DOC19/1016404

21 November 2019

**Multi-Trades and Digital Technology Hub at TAFE Meadowbank (SSD 10349)
Advice on the Environmental Impact Statement (EIS)**

Figure 7: Location of the outdoor workshops in Level 3 (left) and Level 6 (right)

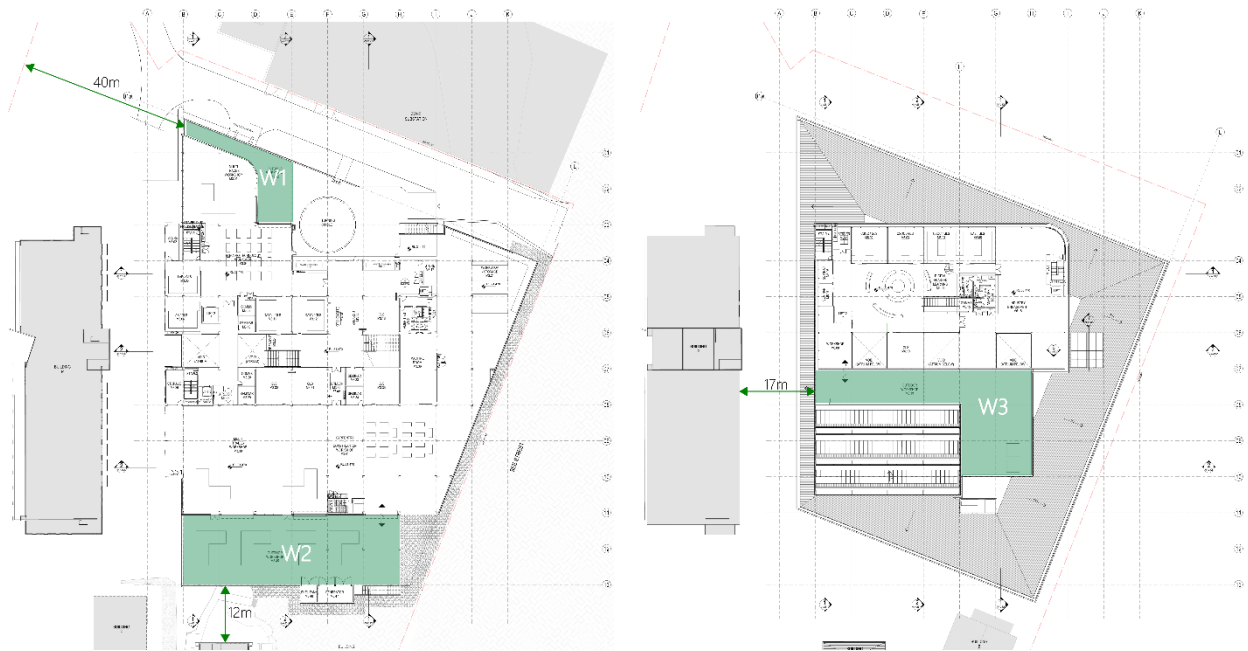
- NVIA, s.5.3.2 – Assessment of noise from outdoor workshops. The assessment has considered three educational receiver locations, however has assessed the predicted noise levels against residential assessment criteria and not the criteria applicable to educational facilities. Fully outline and justify the method used to predict noise levels to the nearest sensitive receiver from the use of the outdoor workshops, including an assessment to the nearest residential receiver locations. The assessment should consider the applicable project noise trigger level derived from the NPfl (EPA, 2017).
